**Re: McDonald's Old Town MRP, 2305 Central Ave,
Traffic Circulation Layout
Engineer's Stamp dated 1/27/14 (J13-D053)**

Based upon the information provided in your submittal received 1/28/14, the above referenced plan cannot be approved for Building Permit until the following comments are addressed:

McDonald's Old Town MRP
Variance Option 1
Rec'd. 12/31/13

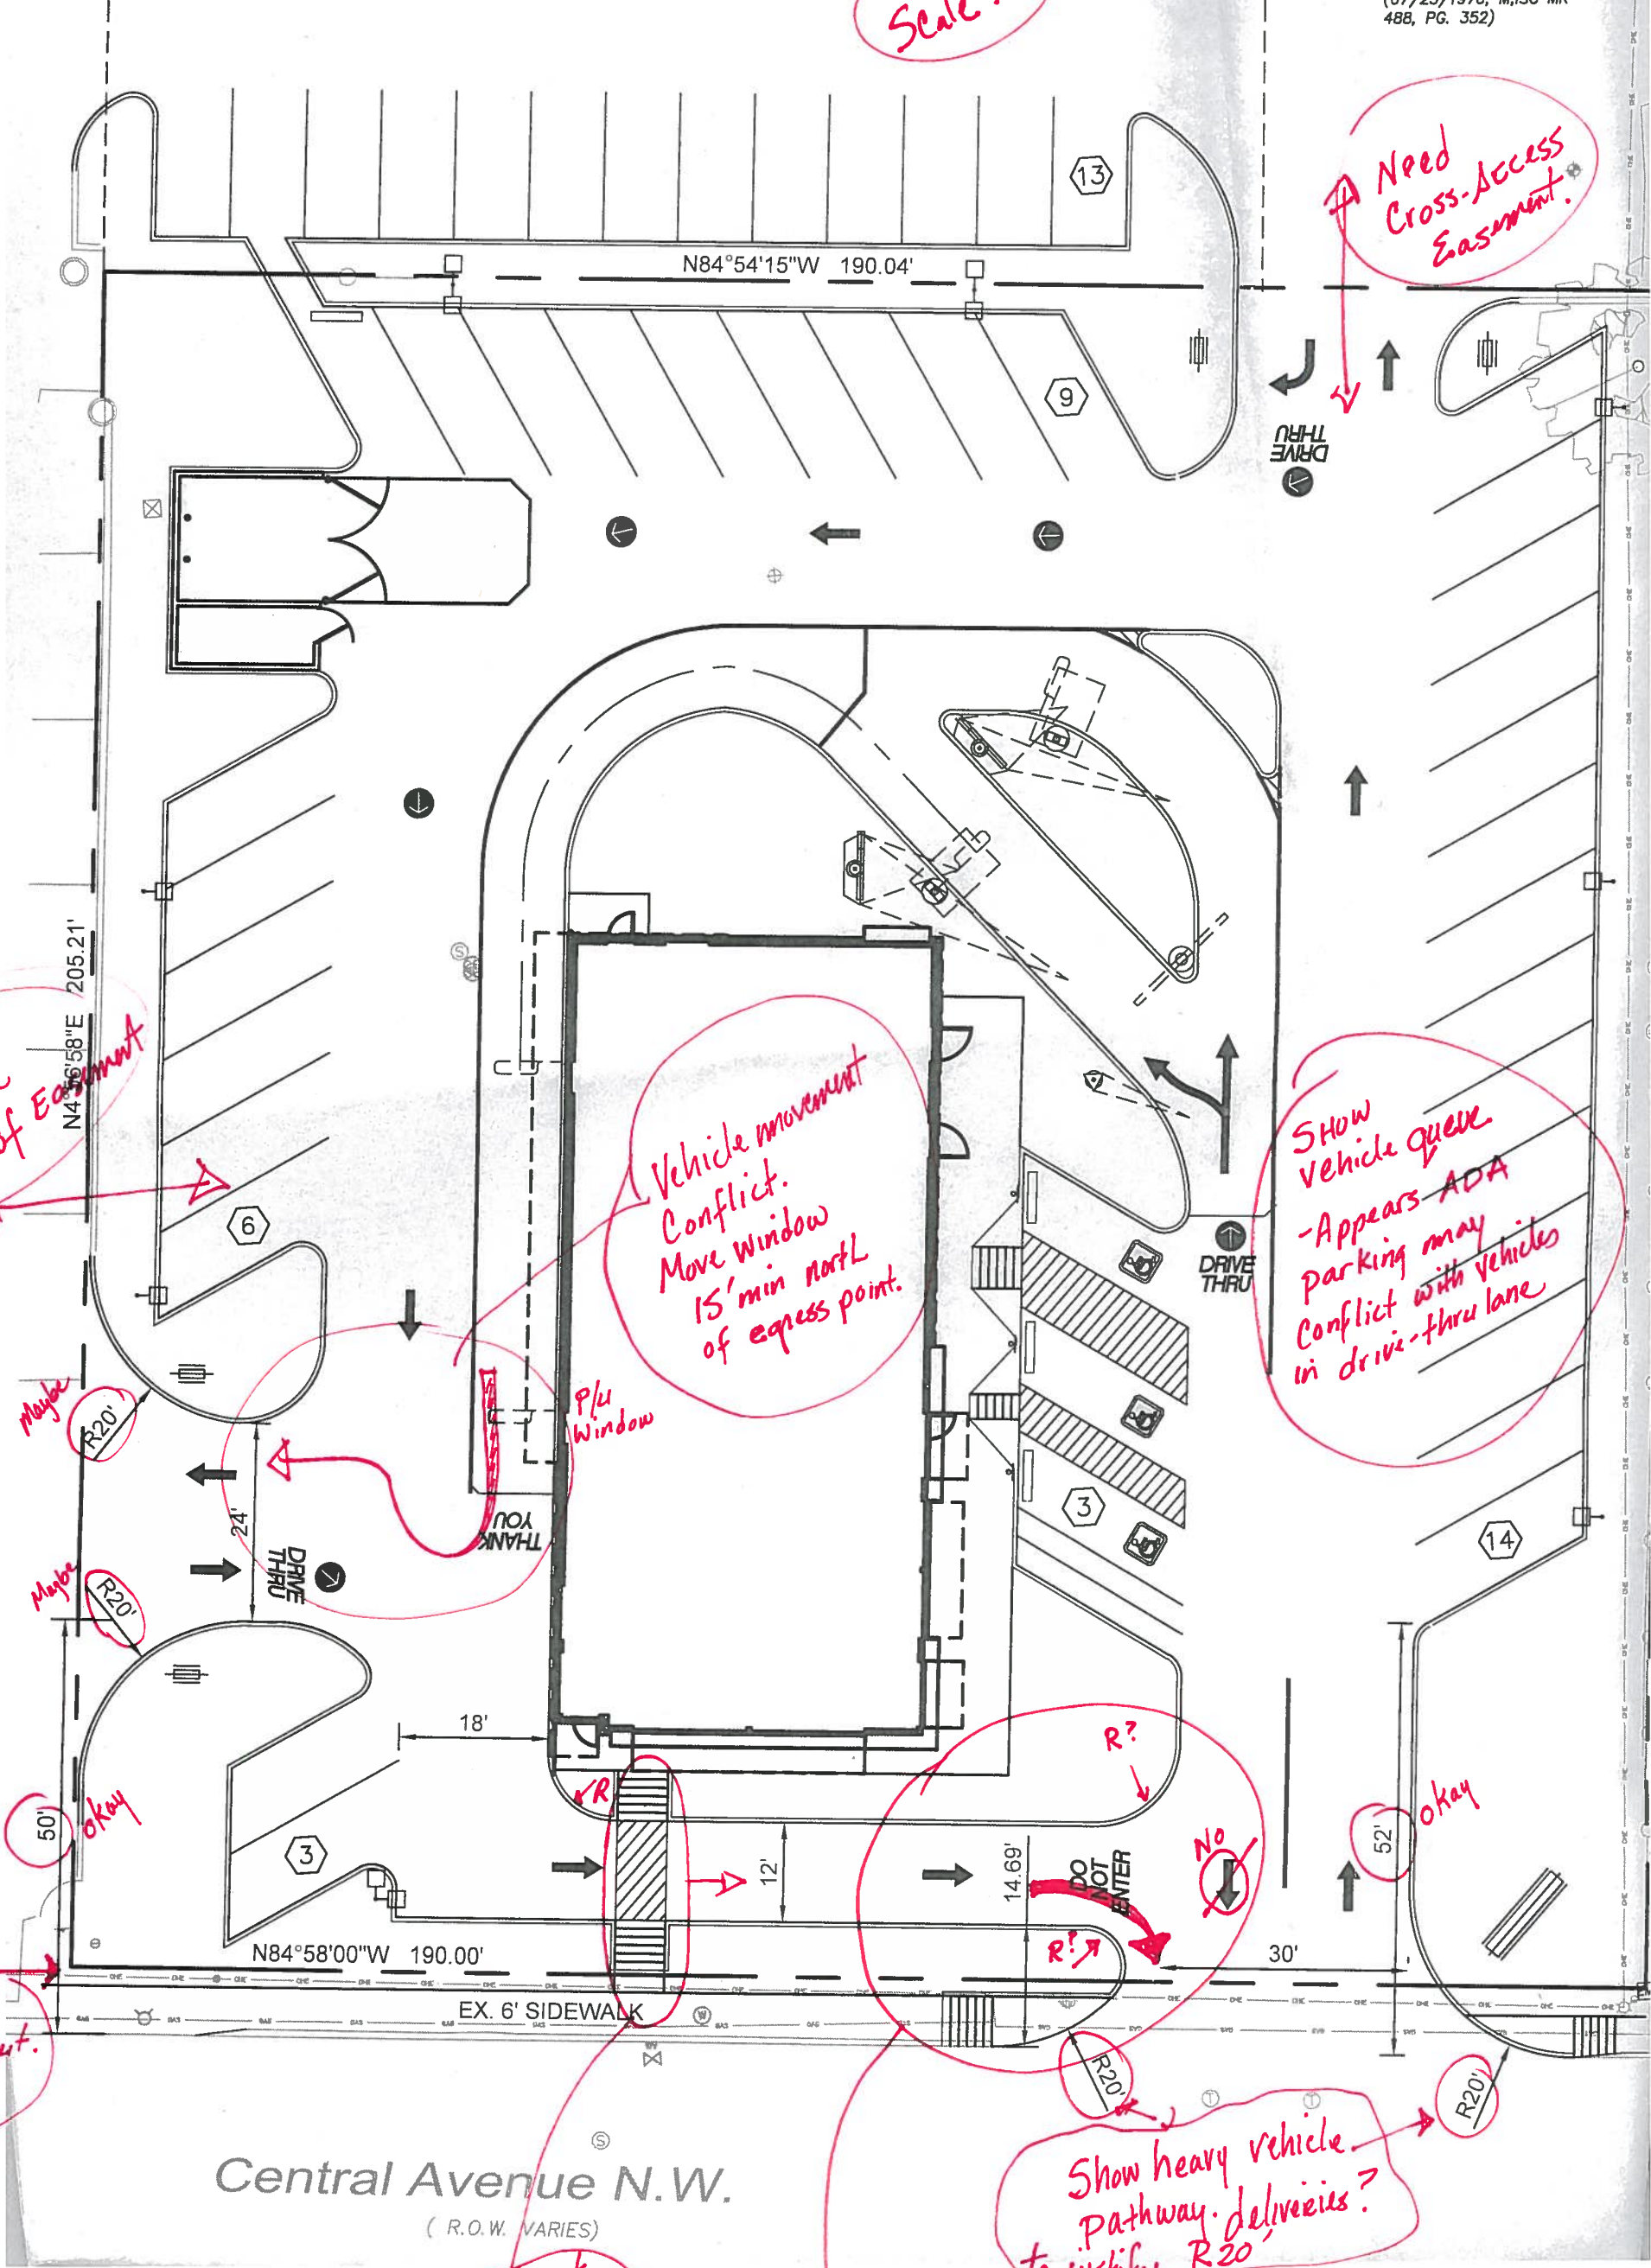
1. Please refer to all applicable city standards.
2. Relationship between site plan keyed note 13 and sheet C-11 detail needs correction, incorrectly references "COT" and "Oklahoma".

3. Per the *DPM*, a 6 ft. wide *ADA* accessible pedestrian pathway is required from the handicap parking stalls to the building entrances. Please clearly show this pathway and provide details. Please include the clear path with the door swing and ramps incorporated.

4. Show a detail of the wheelchair ramps located at the proposed driveway, or refer to the appropriate city standard. Key note 1 references sheet C-11 for ramp detail however this detail is not applicable for the proposed curb return with uni-directional ramps at the entrance from Central.

5. It appears adjacent eastern lot has a driveway cut within 2-3 feet of the eastern property line. Show how proposed infrastructure is tied to the existing. The *ADA* ramp associated with proposed curb return requires an 8 ft run (8" curb height, 12:1 slope) and a landing, minimum 5 ft run at 50:1 slope. If the proposed infrastructure crosses the property line, a letter of acceptance from the adjacent property owner is required to modify their section of COA ROW; otherwise proposed layout must be contained within the property limits and frontage.

6. The proposed infrastructure changes include modifications to the northern parking lot that cross the property line into property identified in submitted Easement Agreement, Lot 5-A-2. Please provide documentation from the owner conveying construction modifications are permissible.

7. The western drive access on Central warrants pavement striping due to its width and median access. Refer to *DPM* Chapter 23, Section 6, Part B.10. If the land owner of Lot 5-A-2 will allow construction modifications to their parking lot for the benefit of McDonald's, then providing appropriate

directional striping would also seem appropriate, acceptable and a reasonable installation.

8. The western drive access on Central does not appear to be ADA compliant. Please provide ADA compliant sidewalk ramps and crossing. Provide details.
9. Some of the listed radii for proposed curves do not meet DPM standards. Per the DPM, the minimum end island radius is 15 feet, and 25 feet minimum on inside edge of drive aisles. The inside radius on the drive-thru lane can be reduce to 15 foot radius with an increase lane width to 14 ft. The Traffic Access Plan submitted to demonstrate a passenger vehicle can maneuver through the proposed 12 ft wide drive-thru lane with a 20.5 ft inside radius is not a strong enough argument to vary from the DPM. This is a new site with no existing obstructions that would warrant variance consideration (see the *DPM*, Chapter 23, Section 6, Part B.7.E).

10. The proposed motorcycle parking spaces do not meet DPM requirement of 4 ft wide by 8 ft long. Please modify.
